**RE: Northbay at Lake Woodmoor, Final Plat SF-16-021 - 1<sup>st</sup> Review Response**

This letter responds to your January 3, 2017 review letter relating to the above referenced project. Responses to review comments are shown in red below.

North Bay at Lake Woodmoor
Shoreditch Heights -- Plan and Profile
El Paso County, Colorado

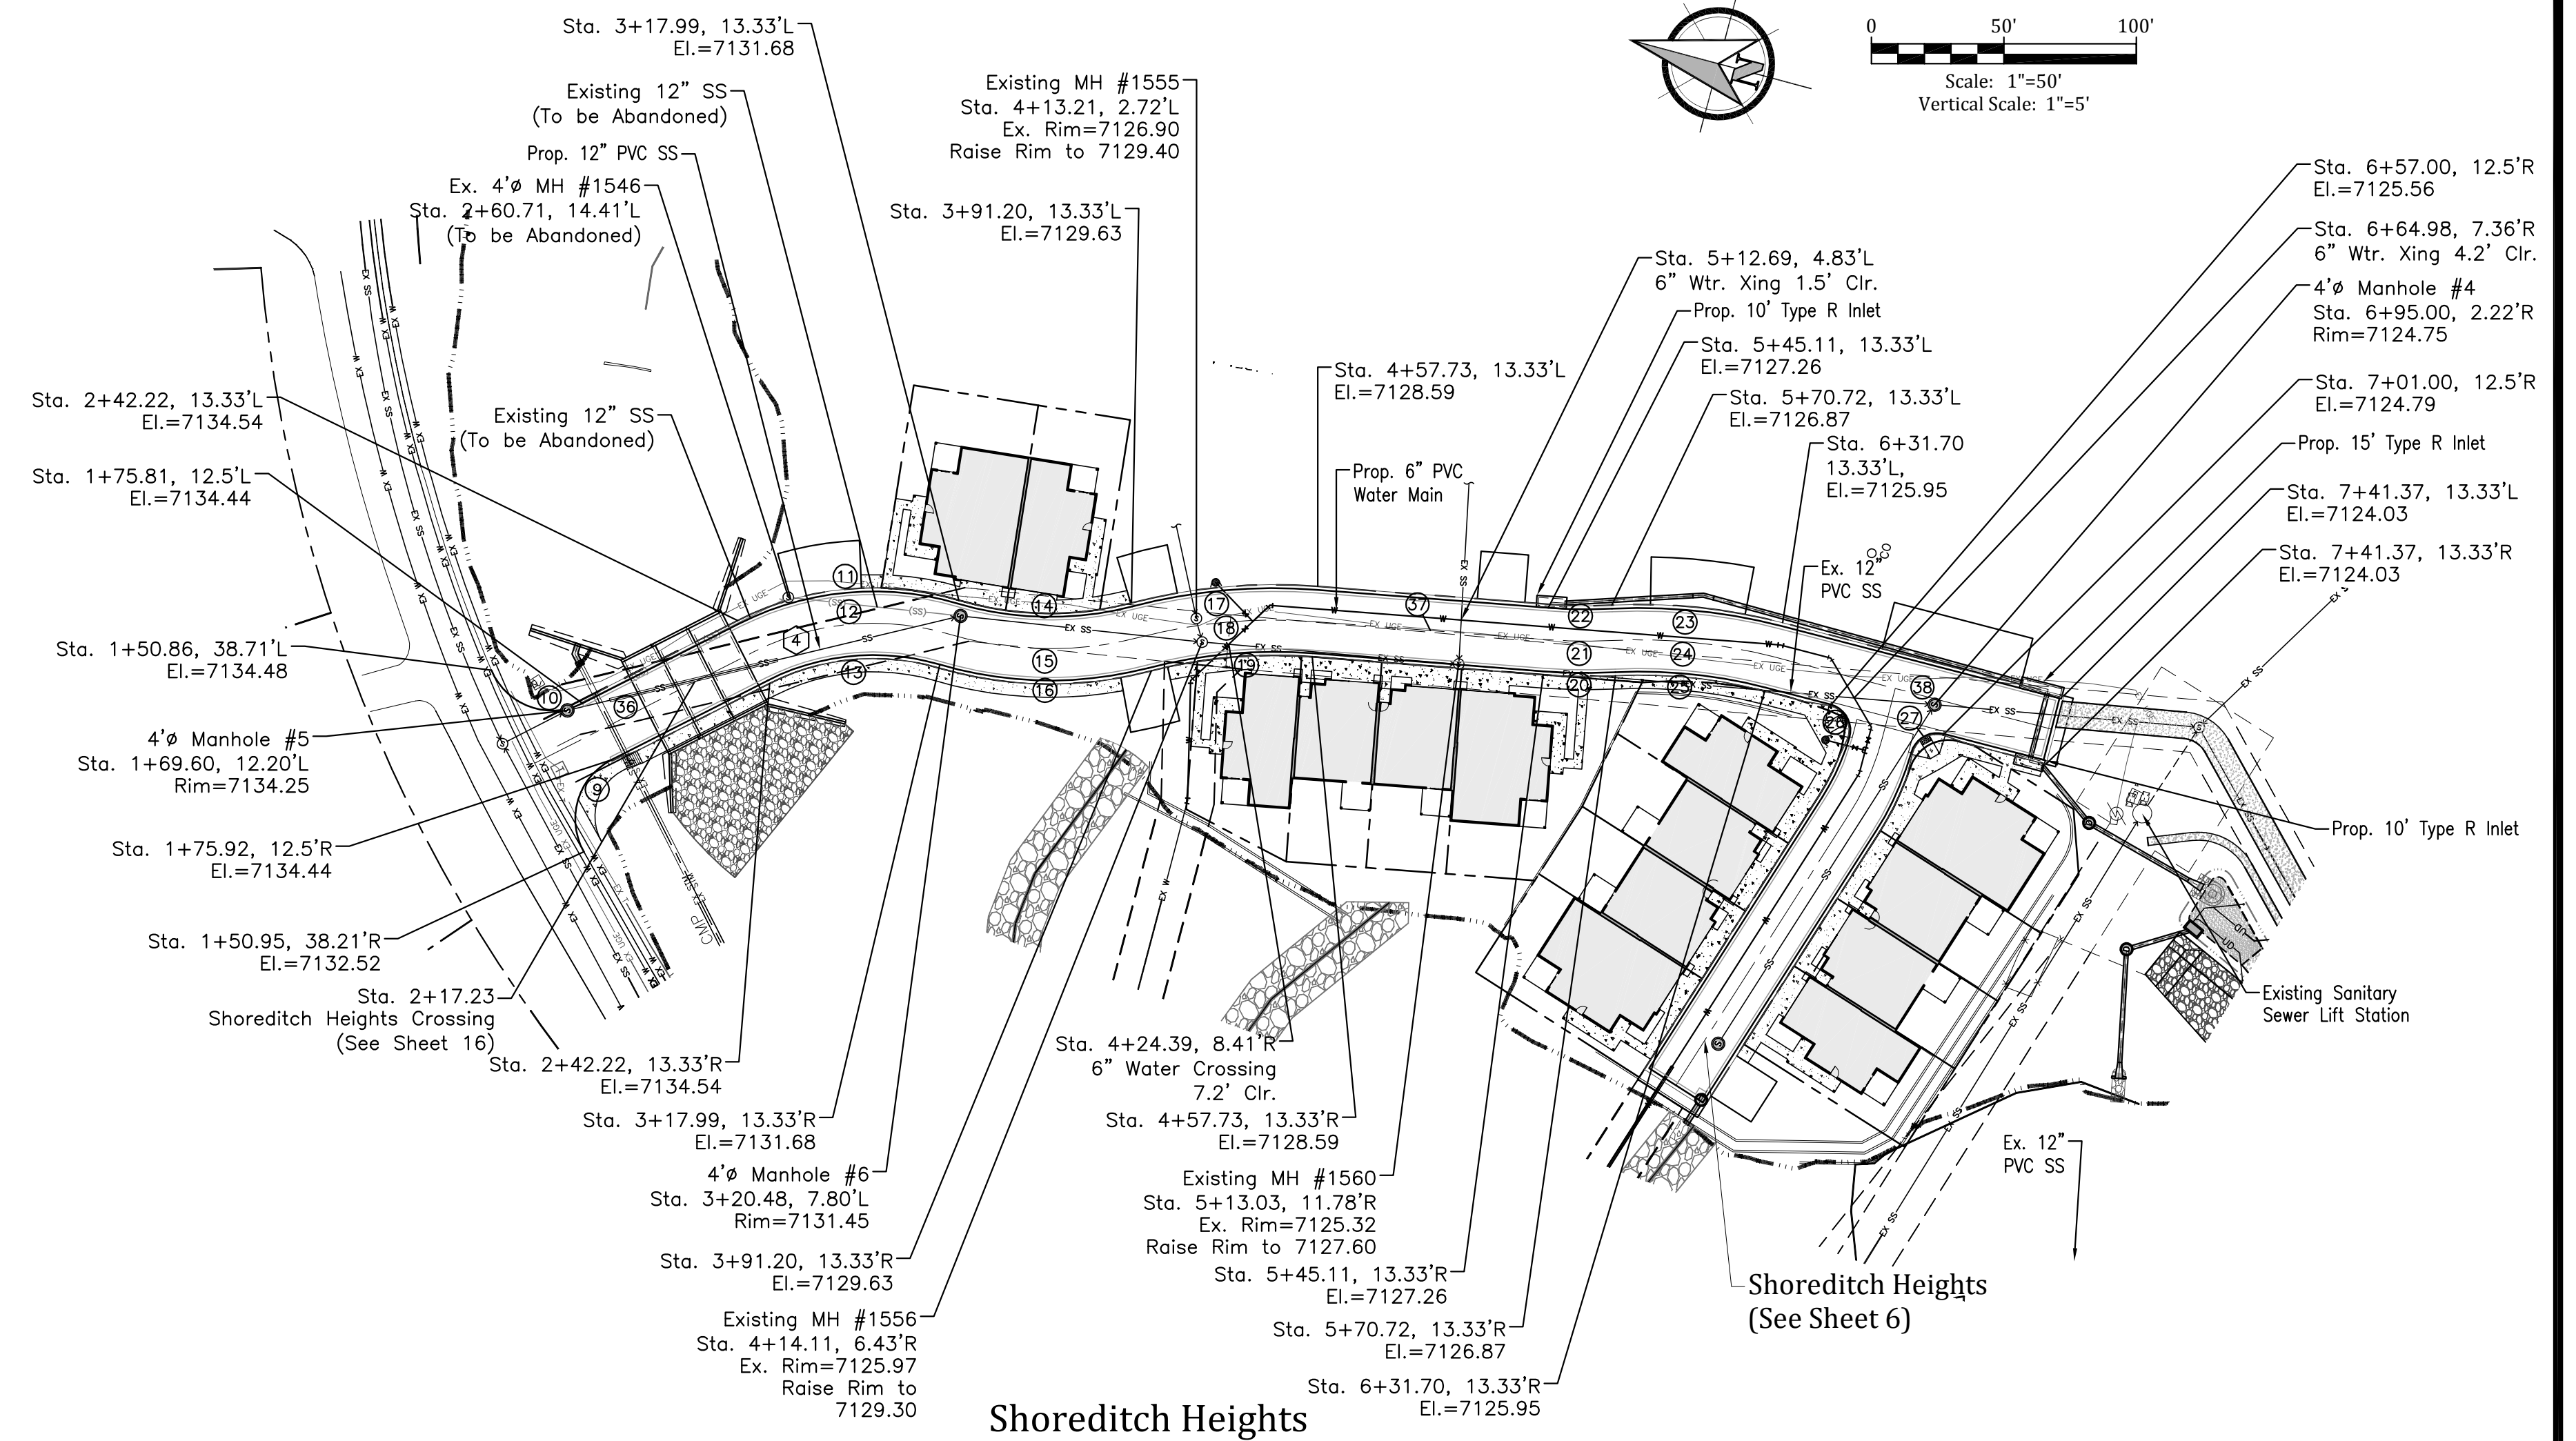
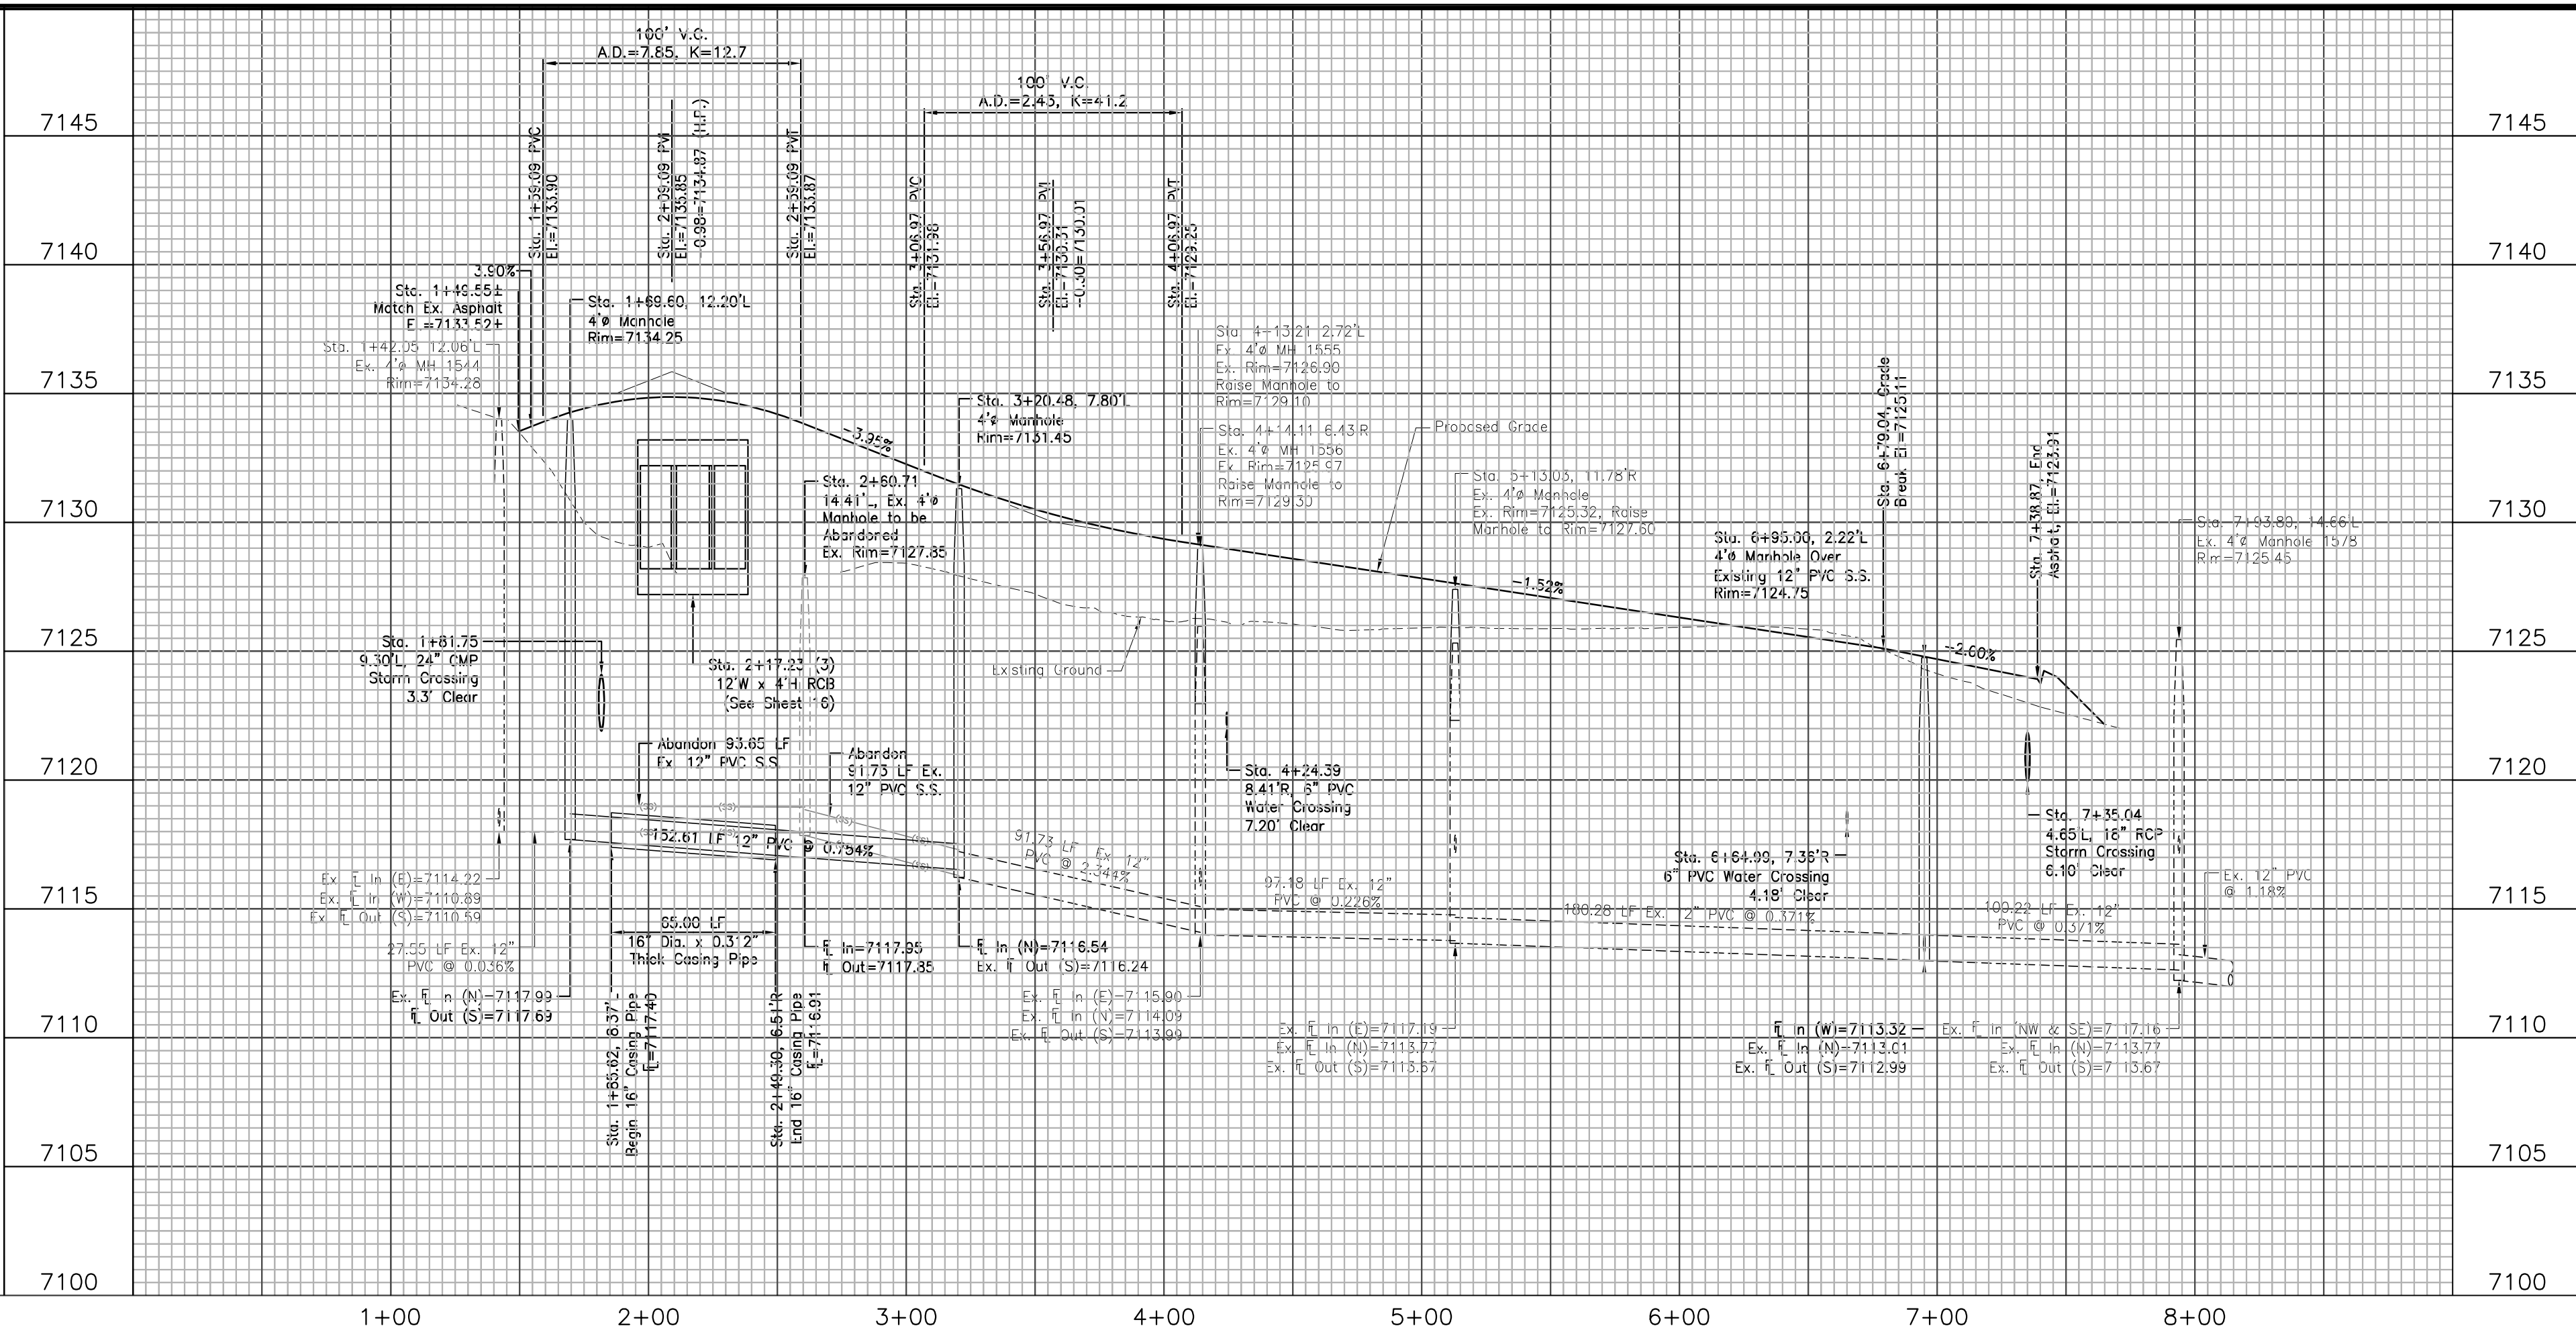
3. Roadway P&P sheets (6 & 7). **Provided and revised**
  - a. Provide the stationing labels along the centerline on the plan view.
  - b. Provide the roadway line data.

- c. Label the proposed and existing grade on the profile view.
  - d. Extend the existing ground profile at Sta 4+91 on Redbridge Point. If the connection to existing ground has an algebraic difference in grade equal to or greater than 1.0%, vertical curve is required. Also, the grade should not exceed 5% due to ADA accessibility.

- e. Include the A.D. and K value in the vertical curve label.
  - f. Revise the pedestrian ramp layout at the hammerhead intersection per ECM detail SD\_2-41.
